Our Ref: P/40/22/NMA

**Section 96A of the Town & Country Planning Act 1990 (as amended)
Town and Country Planning (Development Management Procedure) (England) Order 2015
(as amended) - Article 10**

Non-material amendment following grant of P/70/19/RES to change some brick types on the Materials Schedule to some of the dwelling plots (Plots 51-52, 86-87 and 88-89) and replace rooflights to some plots to dormer windows (Plots 51-52, 86-87 and 88-89).

Land To The West Of Pagham Road Pagham PO21 4NG

HICKSTEAD - Plot-88-89

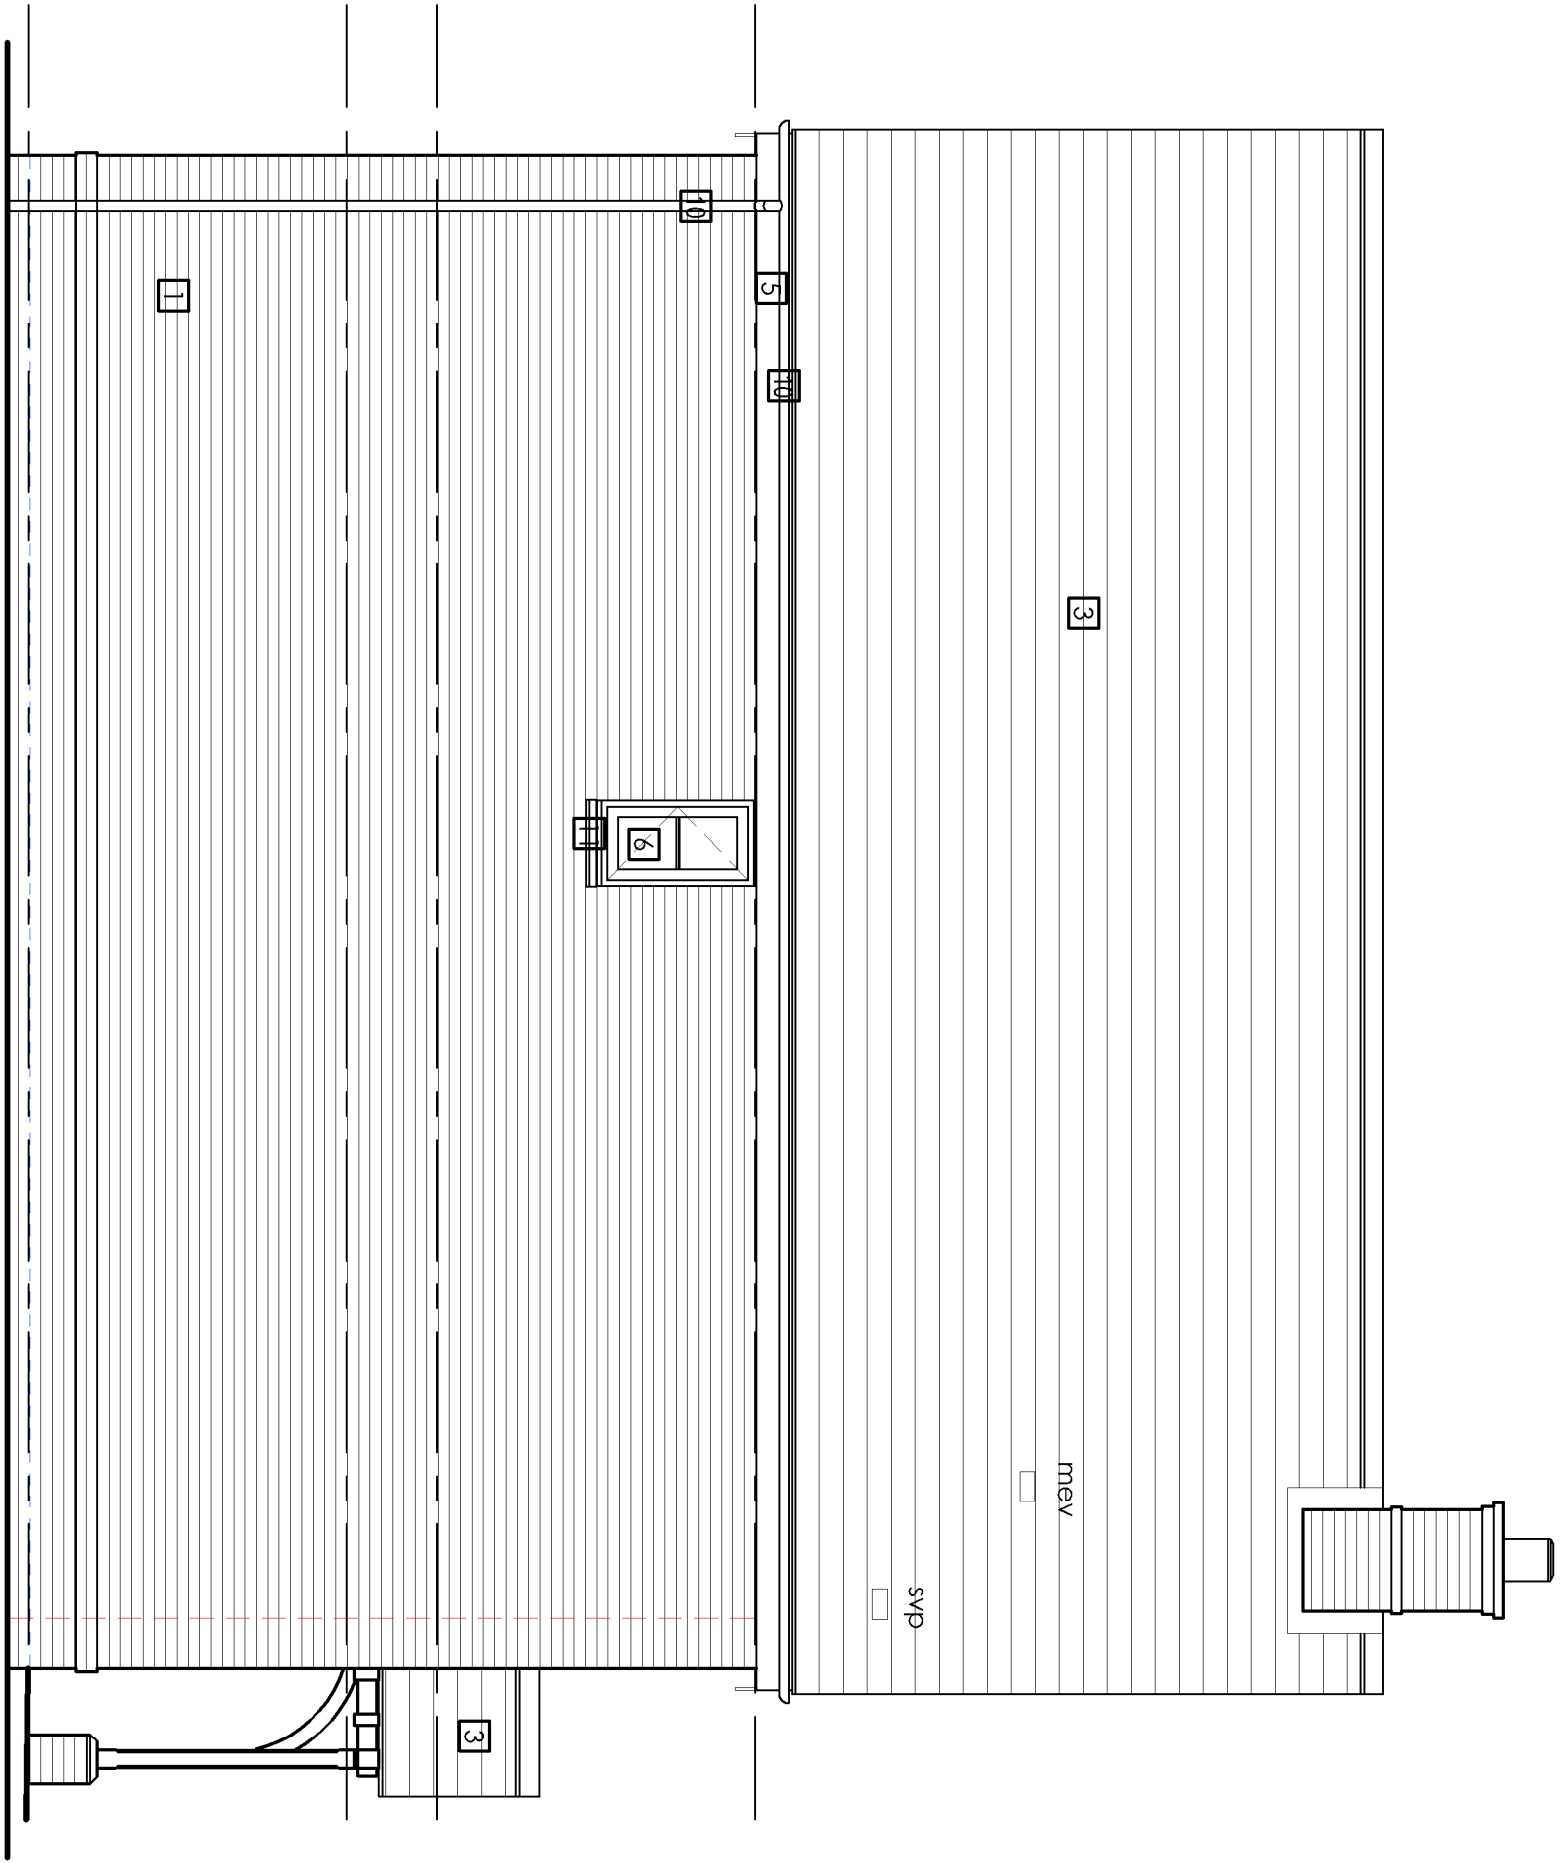
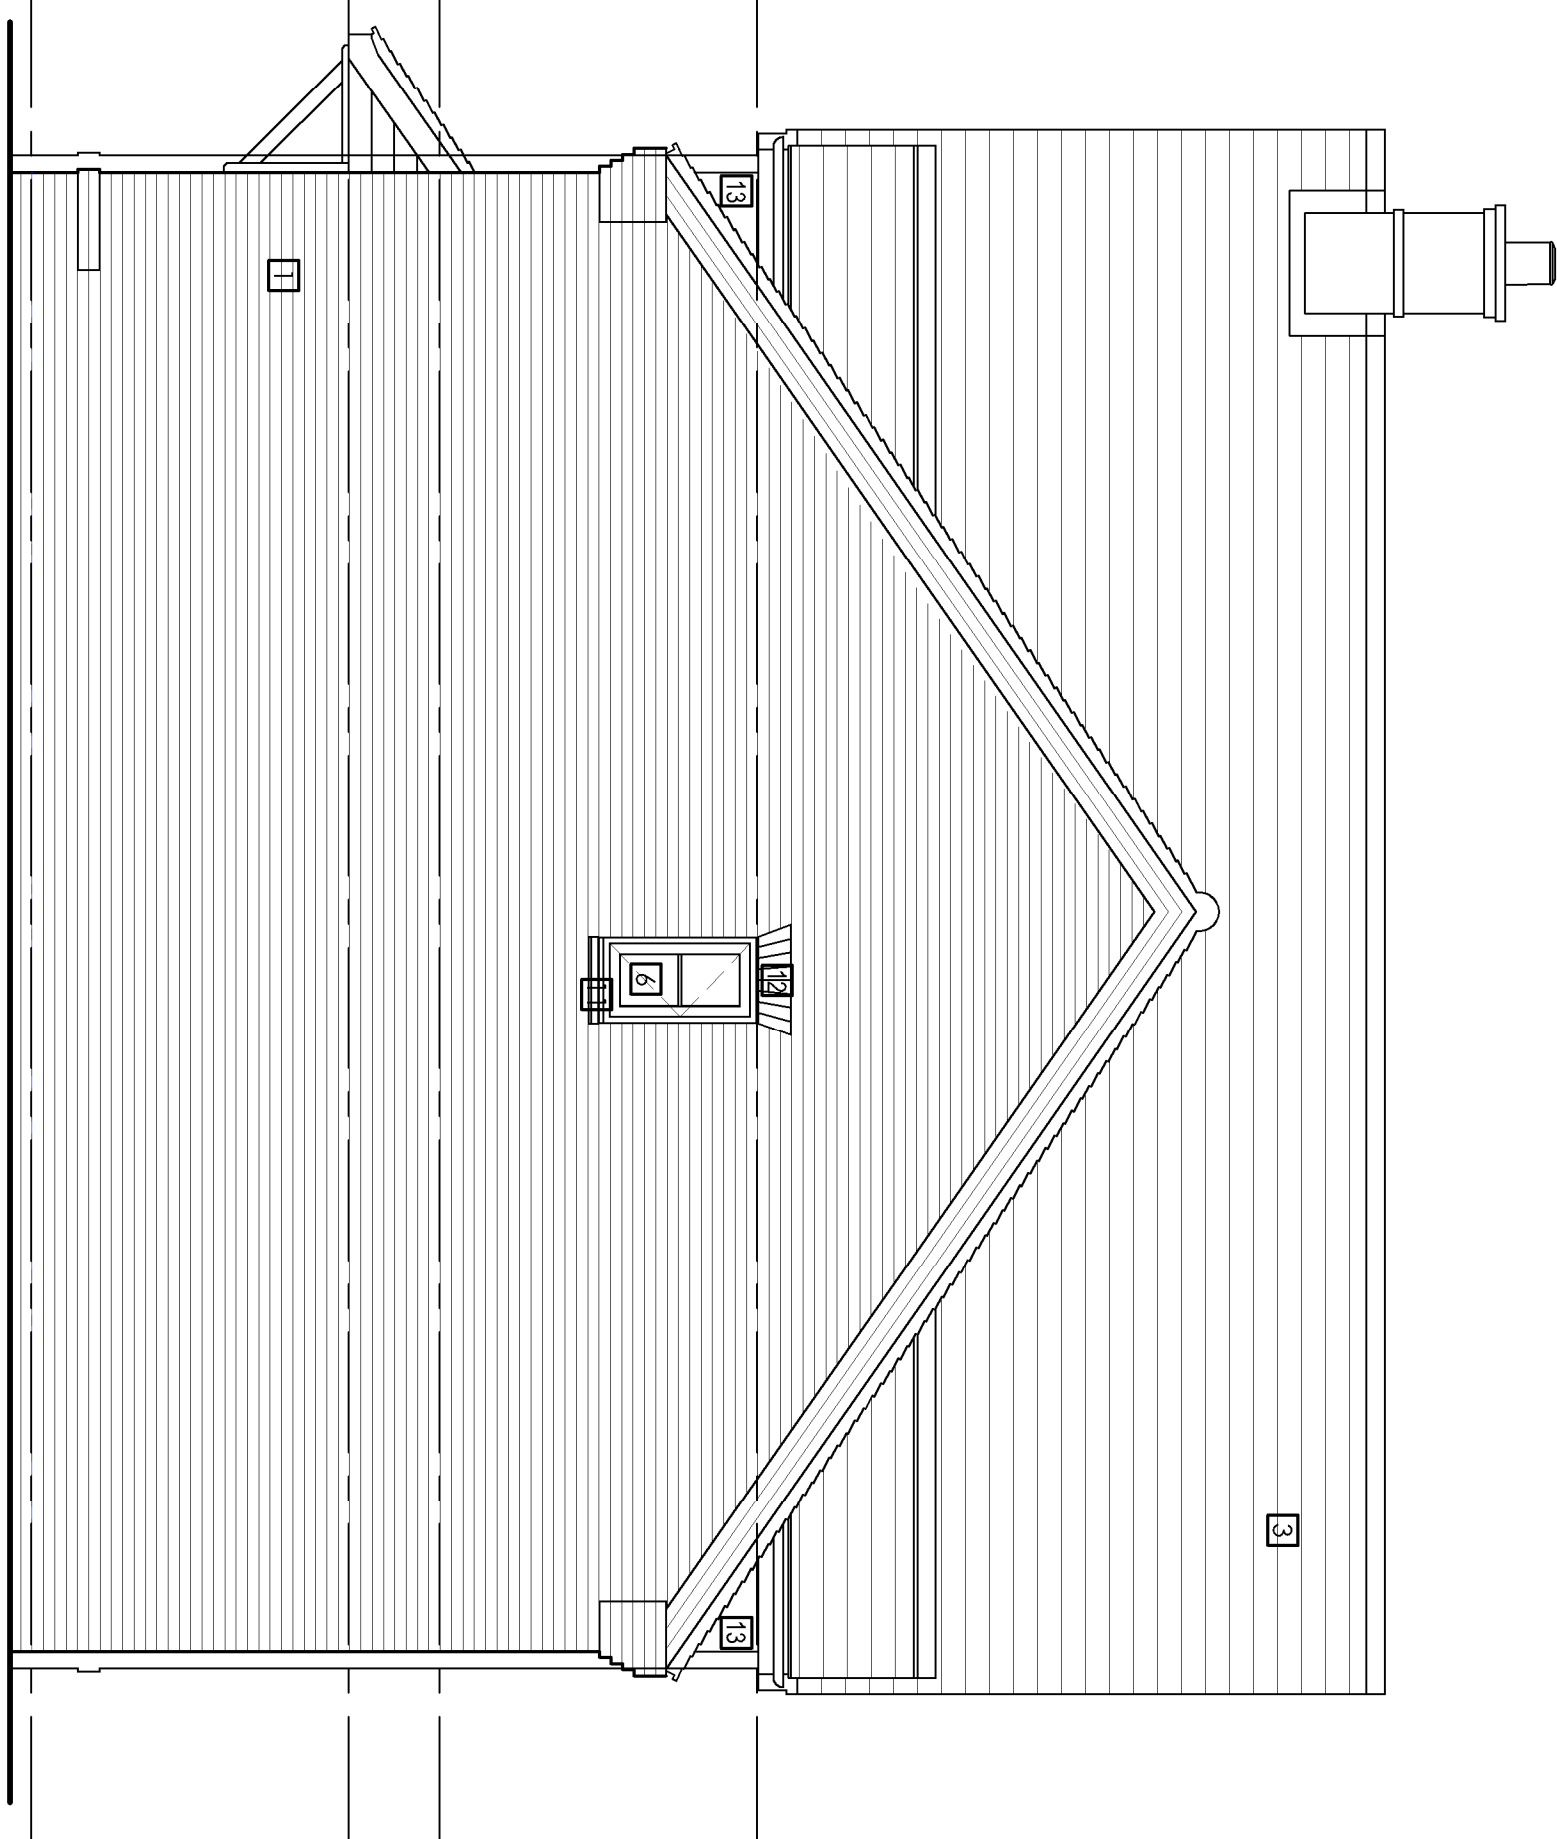
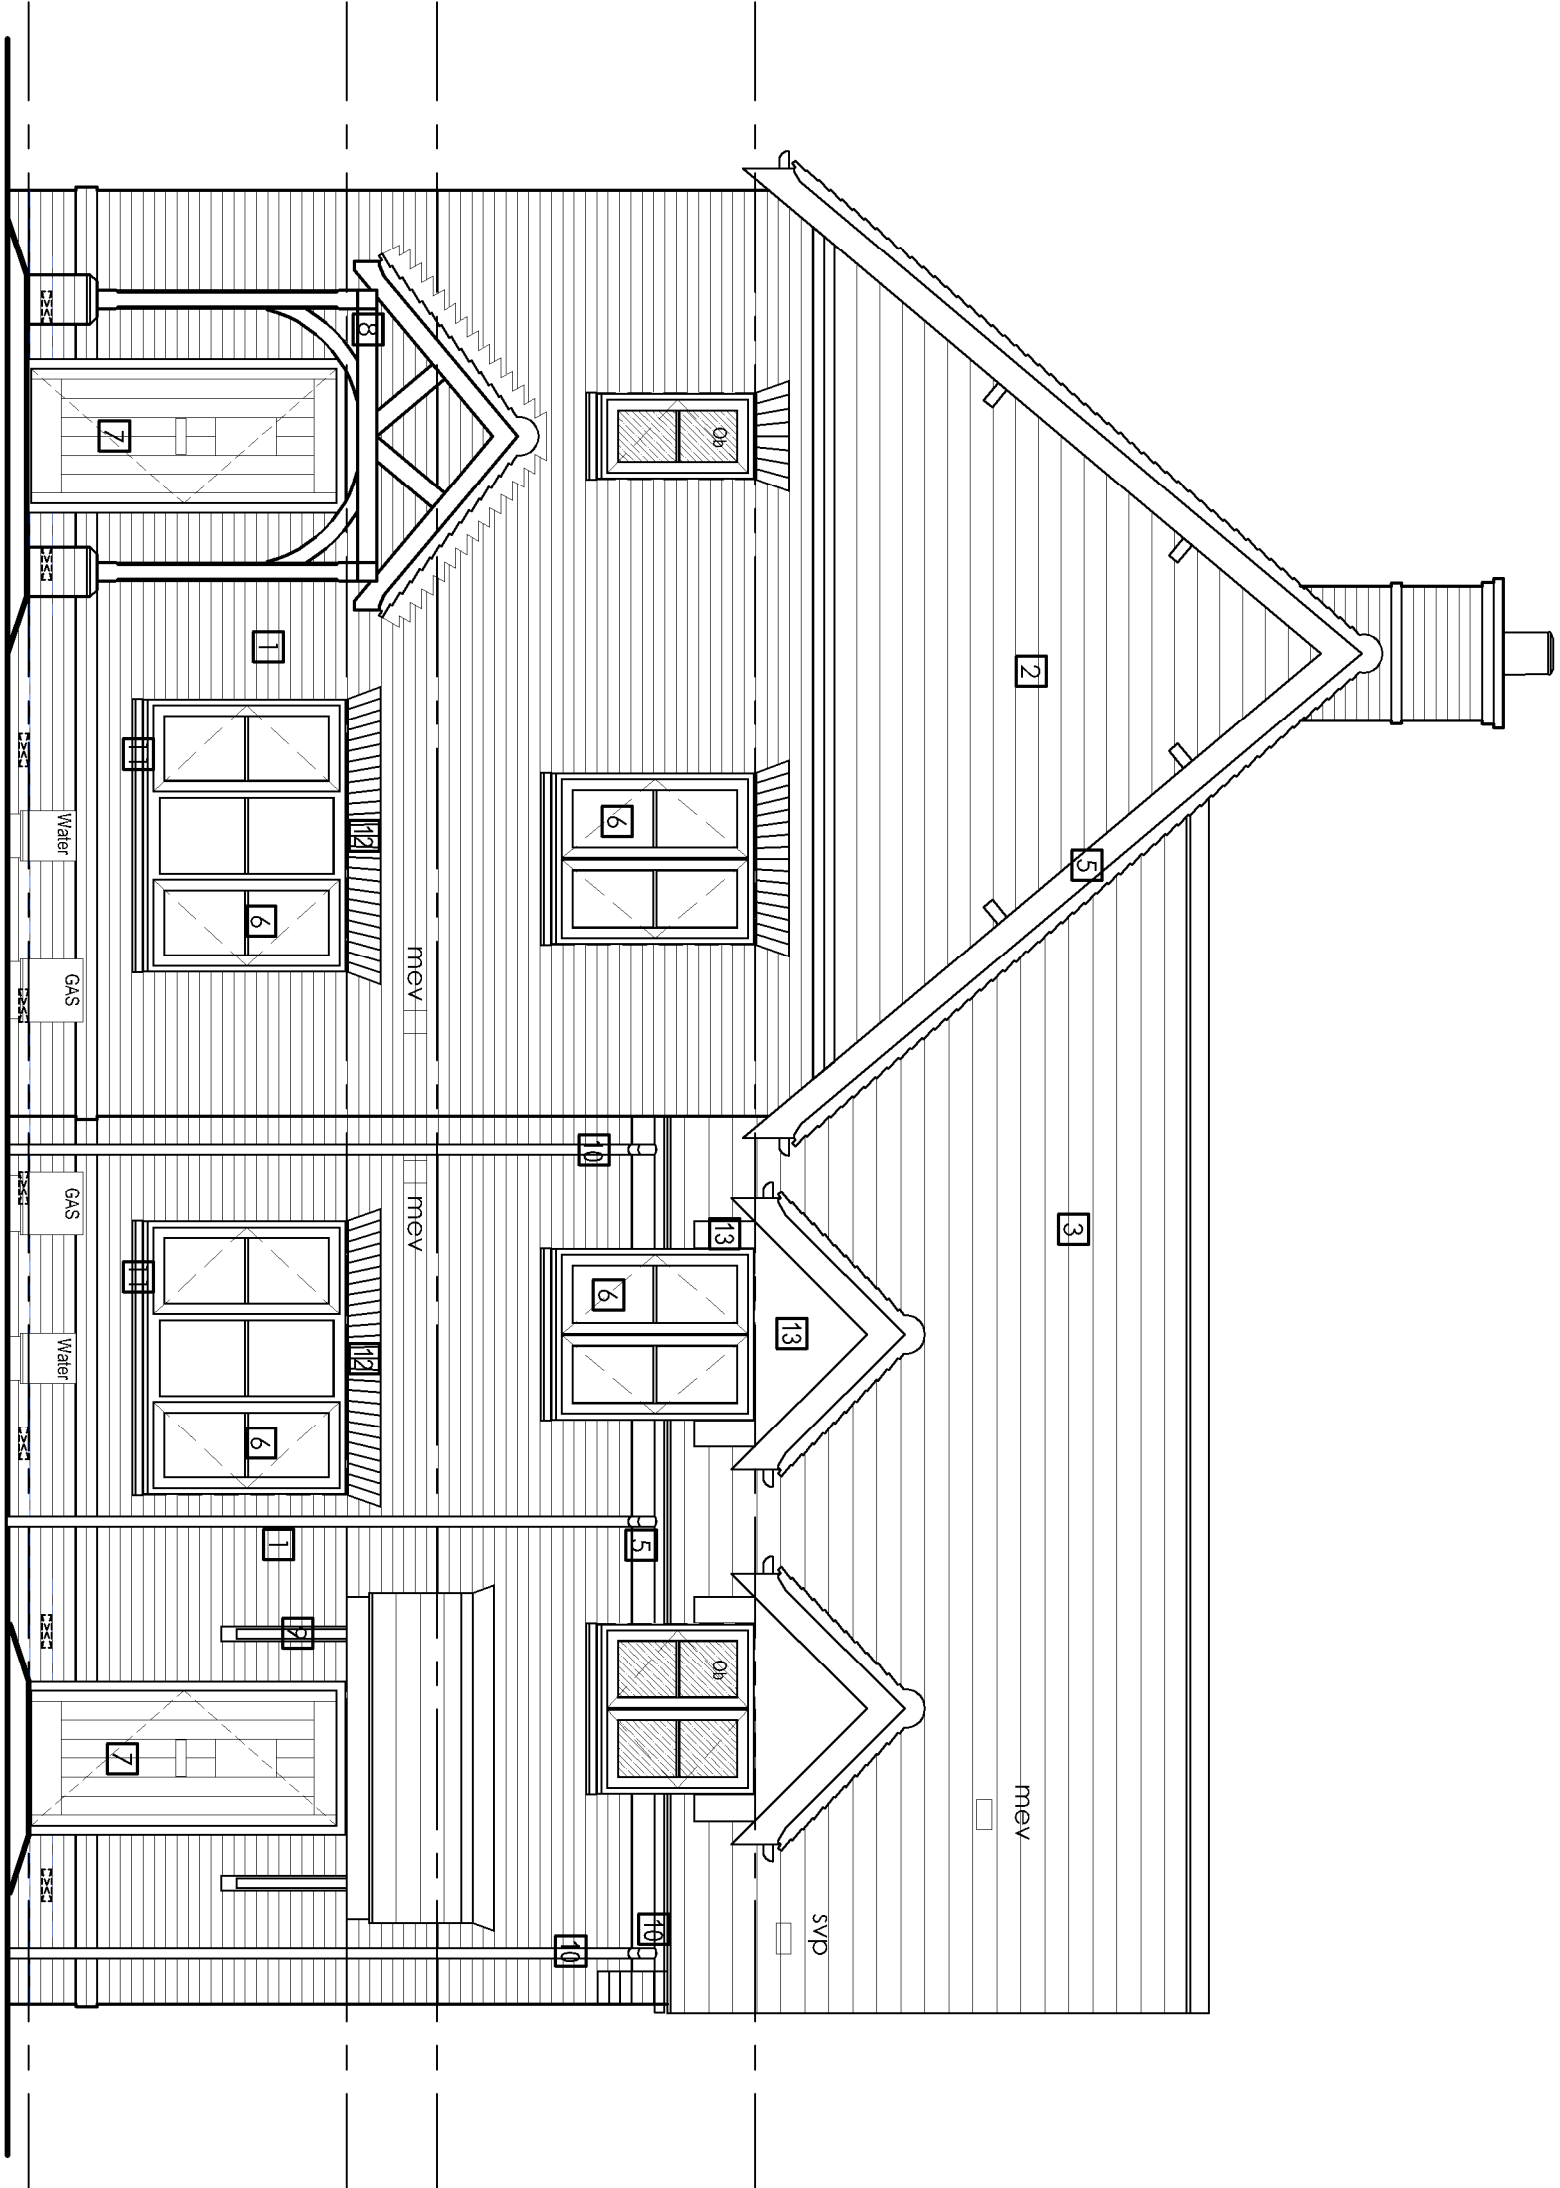
- use Ibstock Thakeham Red Multi Stock to some of the plots;
- use Vandersanden Sundridge Handmade Stock instead to some of the plots;
- replace roof lights on the fronts of the Hickstead house type (plots 51-52 & 86-89 only) with small dormers to match those already on the front and rear elevations.
